CITY OF ALBUQUERQUE

**Re: Lot 6 Block 1 SAD 228
Volcano Cliffs Subdivision Unit 2
6412 Petirrojo Rd. NW
Grading and Drainage Plan
Engineers Stamp Date 11/2/2021 (D10D003F6)
Pad Certification Date 11/16/2021
CO: Not Accepted**

ENGINEER'S SEAL	LOT 6 BLK 10 UN 22 VC 6412 PETIRROJO ROAD	DRAWN BY DEM

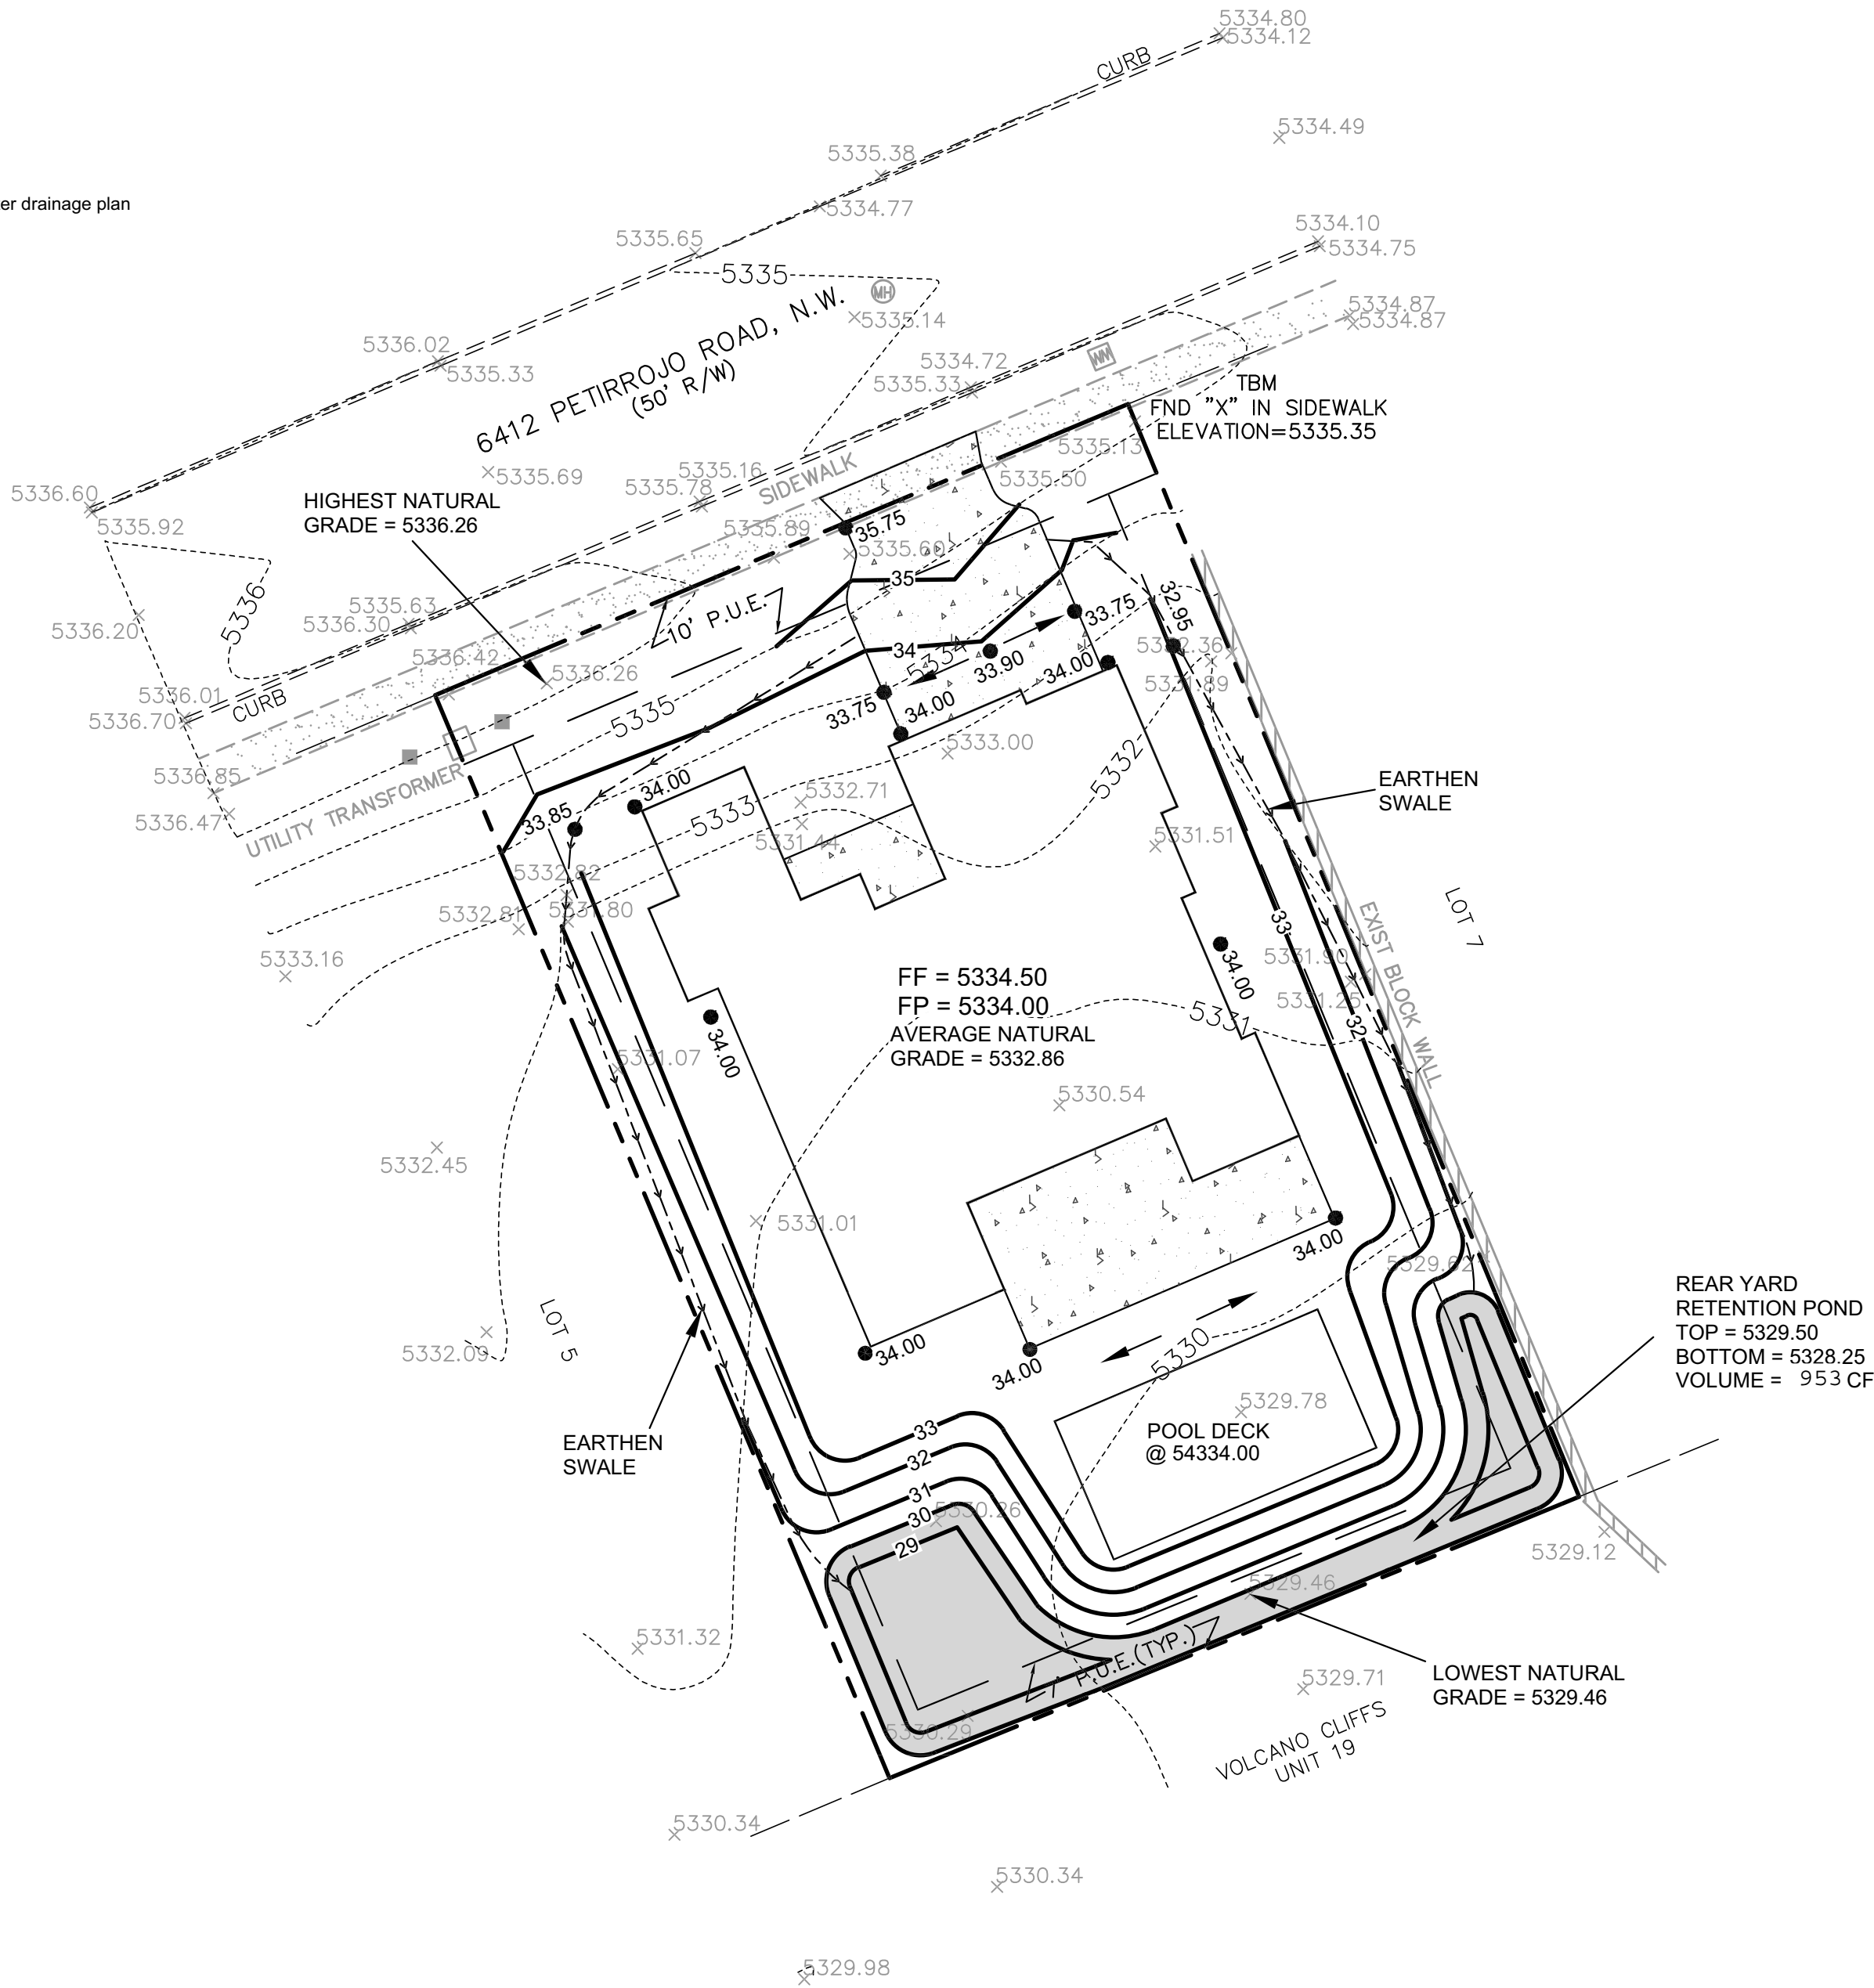
Based on the Certification received 7/22/2022, the site cannot be accepted for release of Certificate of Occupancy by Hydrology until the following comments are addressed.

- Remove the dirt piles and debris from the neighbor's yard.
- Remove dumpster from neighbor's yard.
- The back yard needs to have erosion protection.
- Where the fence is missing blocks needs to be repaired so that no moisture enters the neighbor's yard.
